**WEST SUSSEX COUNTY COUNCIL
INFRASTRUCTURE CONSULTATION**

DATE: 27th May 2010

SUBJECT: BR/117/10 - Demolition of existing office building and erection of 9 no studio apartments over 3 storeys and associated external works.

3, Spencer Street, Bognor Regis, West Sussex, PO21 1AP

Proposed Development -
Site Plan, Floor Plans + Elevations.

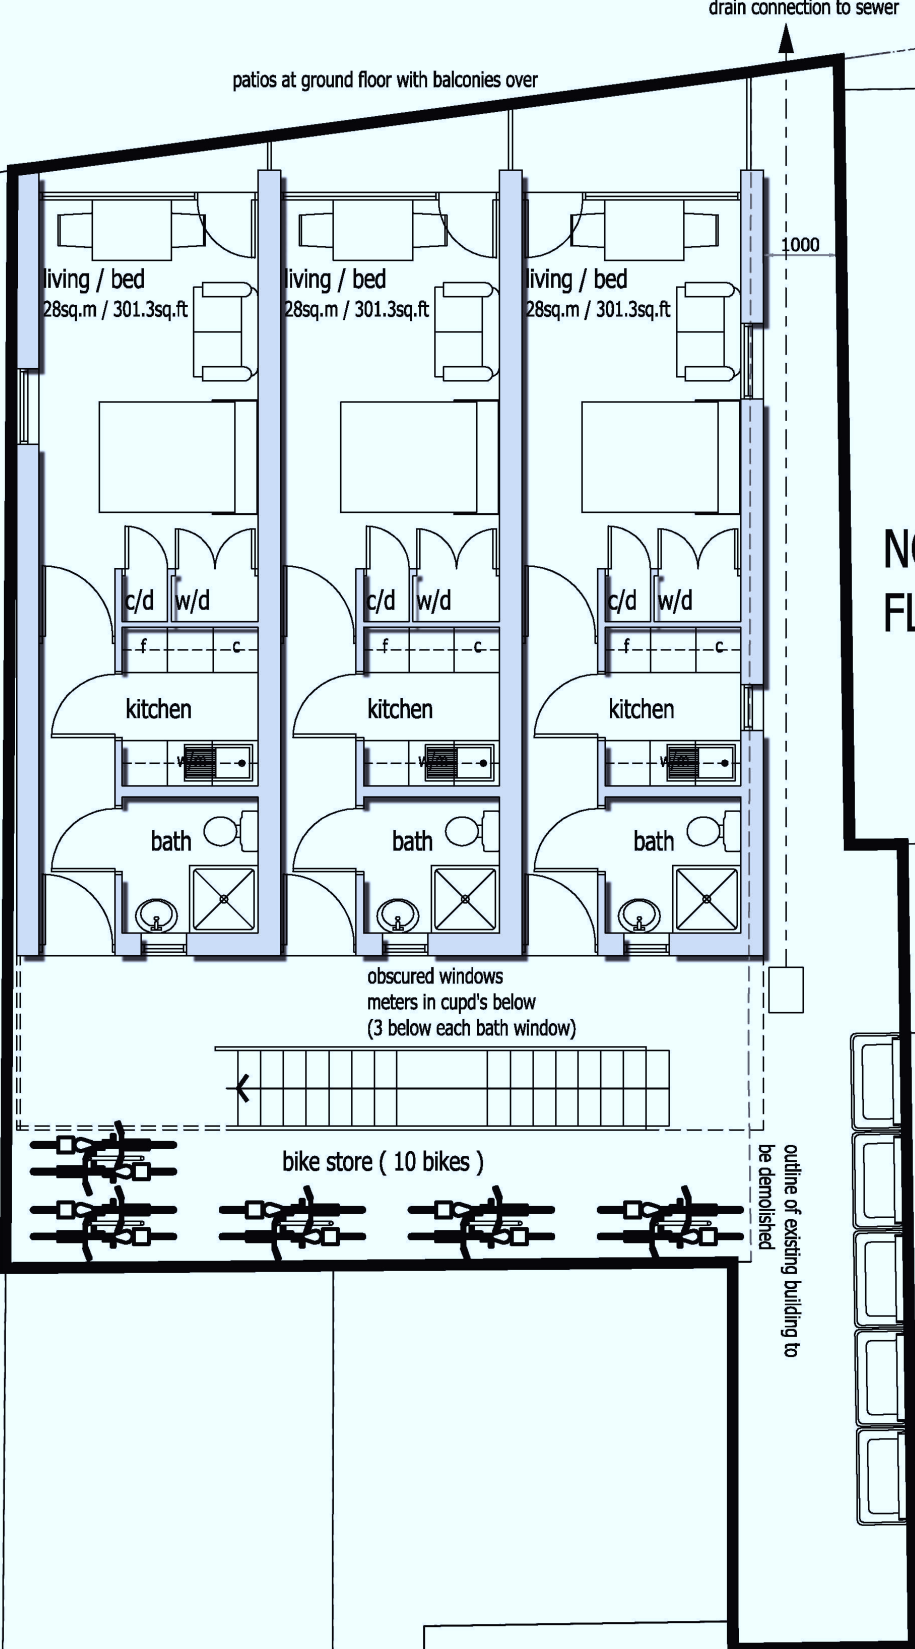
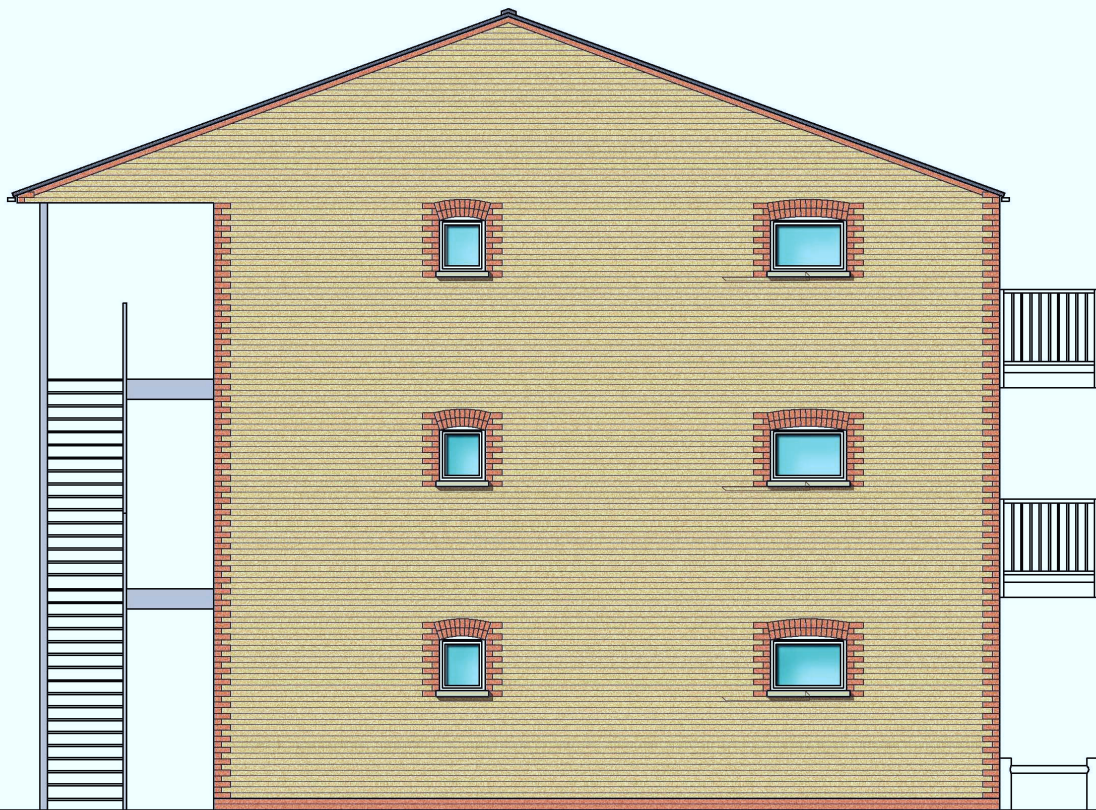
The site has a permitted B1a office use, with a nil car parking provision. The demolition of the existing building and replacement with 9 studio flats also with a nil car parking provision would have an immaterial impact in terms of traffic generation.

With respects to car parking, the WSCC Parking Standards are maximum provisions and are based on national guidance, and allow a developer to provide as much car parking as they consider appropriate providing a low parking provision does not result in any specific highway safety concerns. No specific highway safety issue would be identified as a consequence of this proposal. The Planning Authority may want to consider the implications of this proposal upon on-street parking.

The site lies within walking distance of frequent passenger transport and the facilities within Bognor Regis town centre. The location of the site therefore offers a realistic opportunity to travel by sustainable transport in line with current sustainable transport policy. Cycle parking is to be provided within the building.
